From: Sue Howell
Sent: 04 June 2018 15:21
To: Planning.Responses
Cc: Simon Davis
Subject: RE: Planning Consultation on: BR/90/18/PL

**NOTIFICATION FROM ARUN DISTRICT COUNCIL
Town & Country Planning Act 1990 (as amended)
Town and Country Planning (Development Management Procedure)
(England) Order 2015
Planning Permission
APPLICATION BR/90/18/PL
NO:**

Registered: 22nd March
 2018
Site Address: Formerly Westside Supplies Unit West of 17 & 18
 Durban Road Bognor Regis PO22 9QT
Grid Reference: 493420 100896
Description of Works: Demolition of two storey building & erection of
 three storey block of 8 No. one bedroom flats & 6
 No. two bedroom flats with access from Durban
 Road (resubmission following BR/87/16/PL).

Metres
18 Durban Road
Bognor Regis
Site Plan 1:1250
A4 Paper

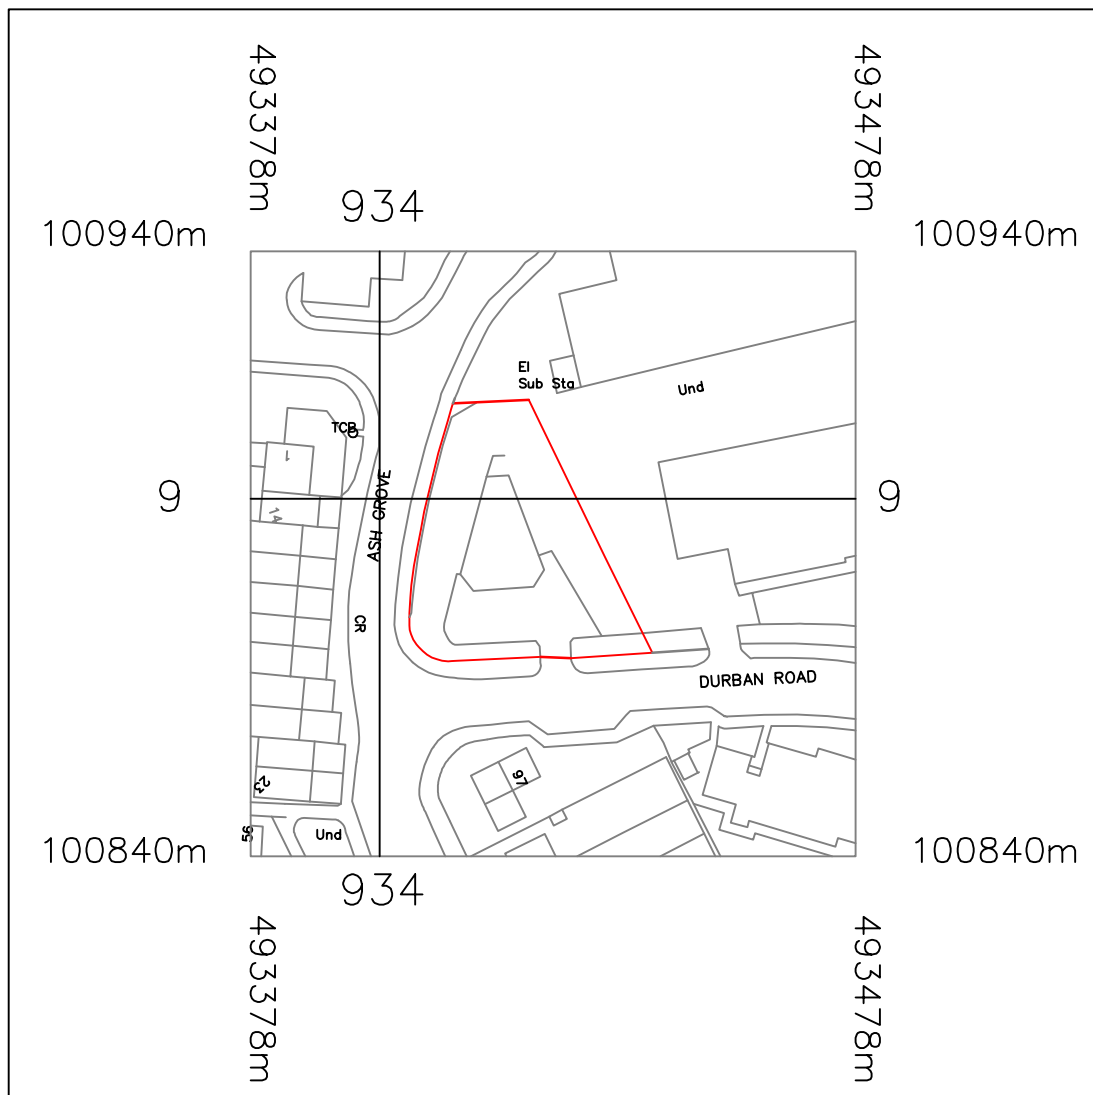
The existing trees in particular along the boundaries and to the north of the proposals provide potential valuable screening and should be protected from construction damage. Root protection Areas (RPA) should extend into the development site and to those in neighbouring land. Before construction, a tree protection scheme must be in place for any adjacent trees whose root protection areas fall within the construction zone from neighbouring land. This should be in accordance with BS 5837:2012 'Trees in relation to construction'
